Re: District 505 – Tower 10
300 San Mateo Blvd NE
Traffic Circulation Layout
Architect's Stamp 05-09-2022 (K18-D065A)

Based upon the information provided in your submittal received 05-11-2022, the above referenced plan cannot be approved for Building Permit until the following comments are addressed:

A3 TRAFFIC CIRCULATION LAYOUT

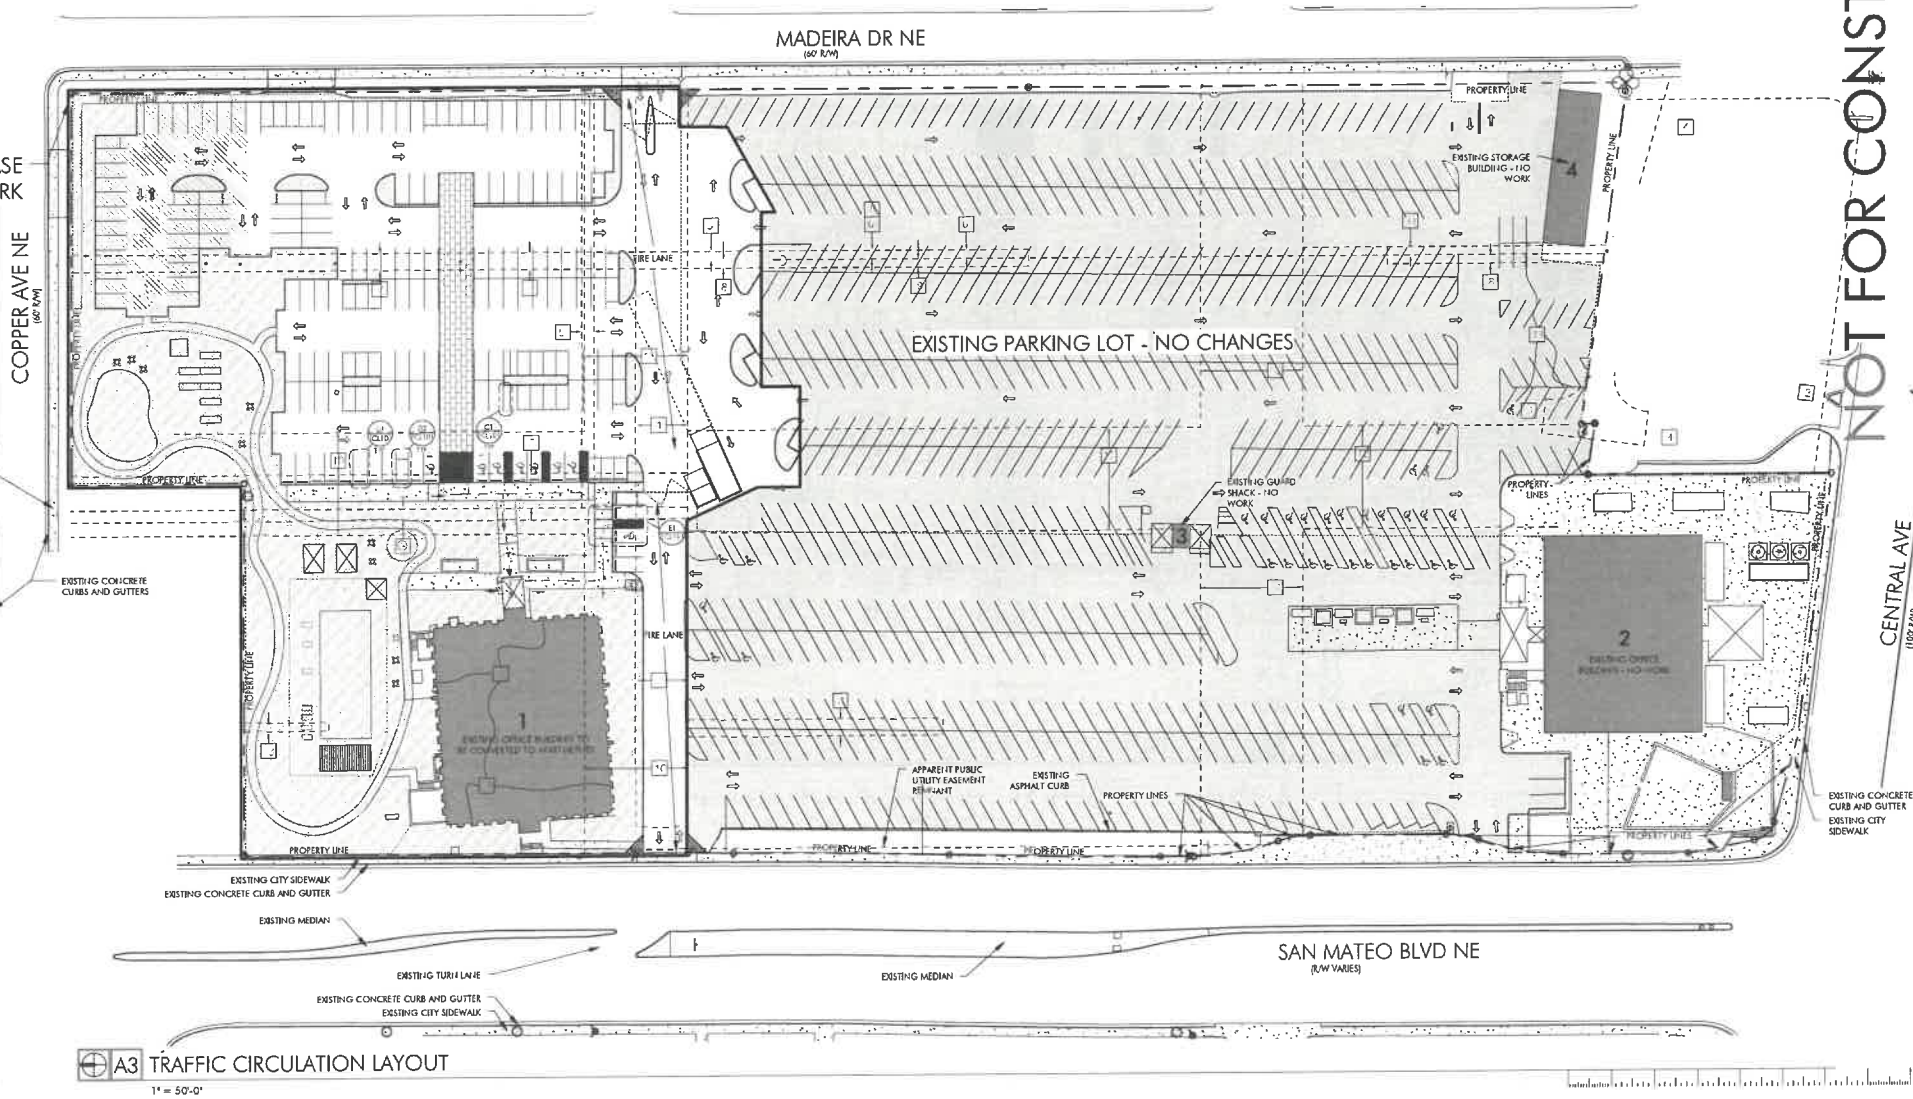
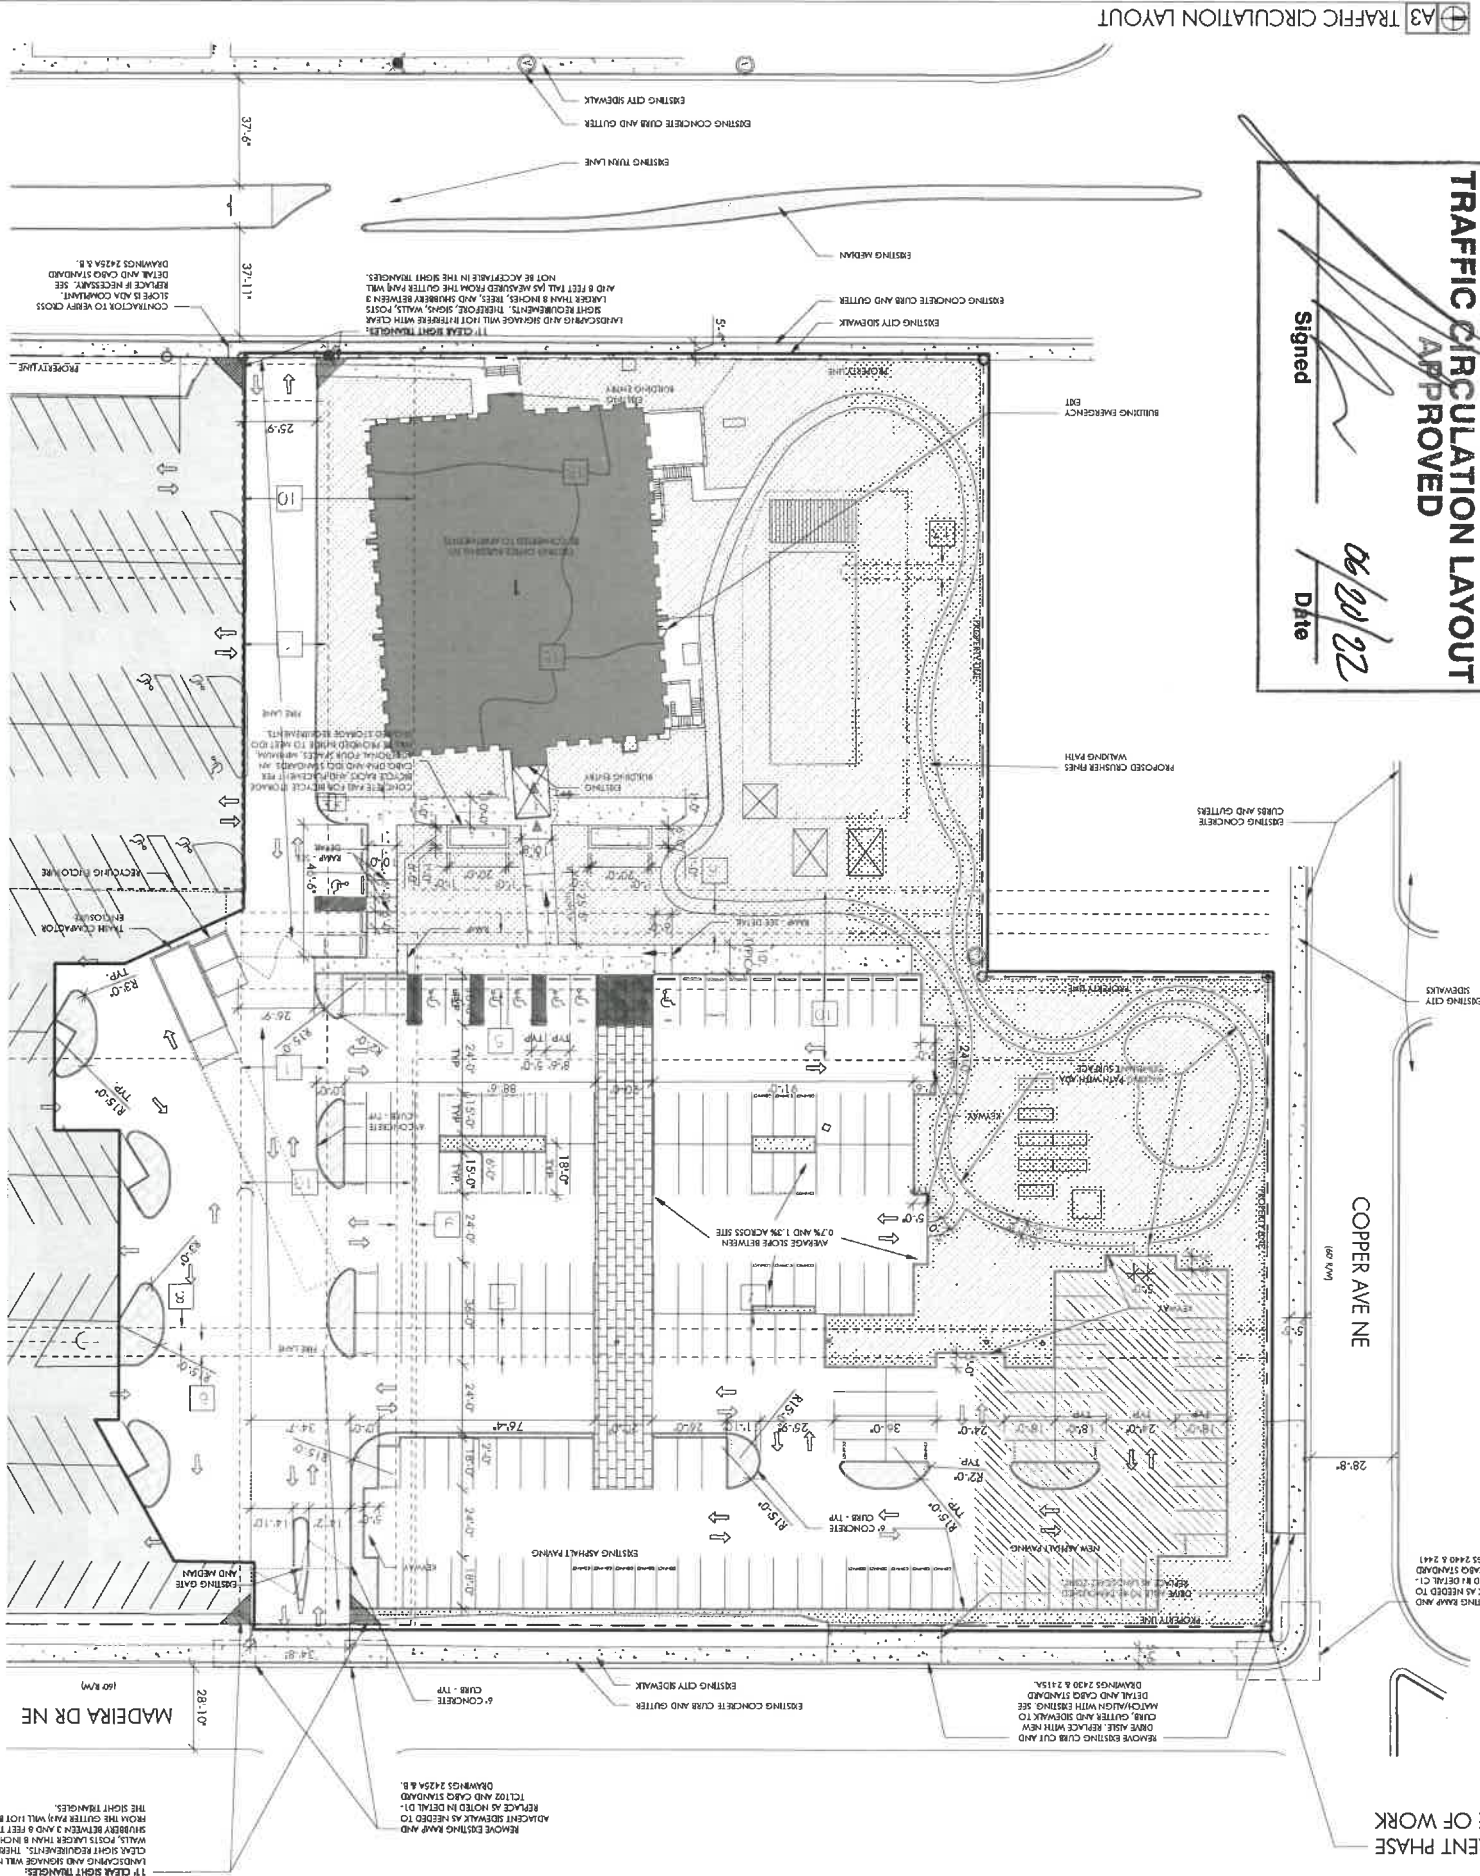
3. You are removing ADA parking stalls from the northern frontage of existing building. Where is the replacement for these stalls?
4. Clarify the extents of the current phase. Provide a phasing plan and/or identify all proposed infrastructure (includes parking stalls, parking bumpers, etc...) Your Site Plan legend doesn't include all improvements.

5. Madeira driveway entrances: Internally has an existing median but no width dimension. Please include dimension to assure that Refuse and Fire Dept. vehicles can traverse without any impacts to median.

6. All existing sidewalk widths around the parameter of Site development will need to be provided.
7. Please identify all existing buildings, doors, structures, sidewalks, curbs, drive pads, wall and anything that influences the parking and circulation on the site.

8. Please list the width and length for all existing and proposed parking spaces. Some dimensions are not shown.
9. The minimum parking stall dimensions are:

12. Each ADA parking stall must have an access aisle to service stall and pathway into Building entrance. **This will need to be provided.**
13. **Copper/Madeira Dr corner ramp:** ADA curb ramps must be updated to current standards and have truncated domes installed. Provide details.

20. Show all drive aisle widths and radii. Some dimensions are not shown.
21. List radii for all curves shown; for passenger vehicles. Radius for delivery trucks, fire trucks, etc. is 25 ft. or larger.

22. A 5 ft. keyway is required for dead-end parking aisles (**label and provide dimensions**).
23. Per DPM, a 6 ft. wide ADA accessible pedestrian pathway is required from the ADA parking stall access aisles to the building entrances. Please clearly show this pathway and provide details.

24. Curbing should be installed to delineate landscape, parking, and pedestrian ways and identify points of access. **Please call out detail and location of barrier curb.**

D1 DRIVEPAD & SIDEWALK (BASED ON CABQ STANDARD DRAWING #2425B-A)

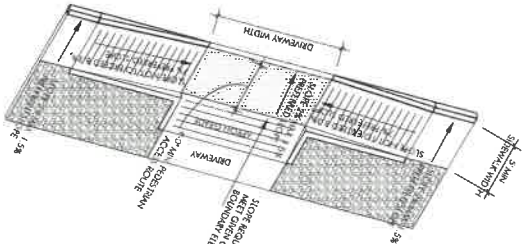
14. Existing Driveways/entrances off San Mateo and Madeira will need to be current/updated ADA accessible across driveway, please address this concern.

30. **Copper Ave Frontage (Existing curb cuts/driveway)** :Unused curb cuts/driveway must be closed replaced with sidewalk and curb & gutter. A build note must be provided referring to the appropriate City Standard drawing (2430 & 2415A).
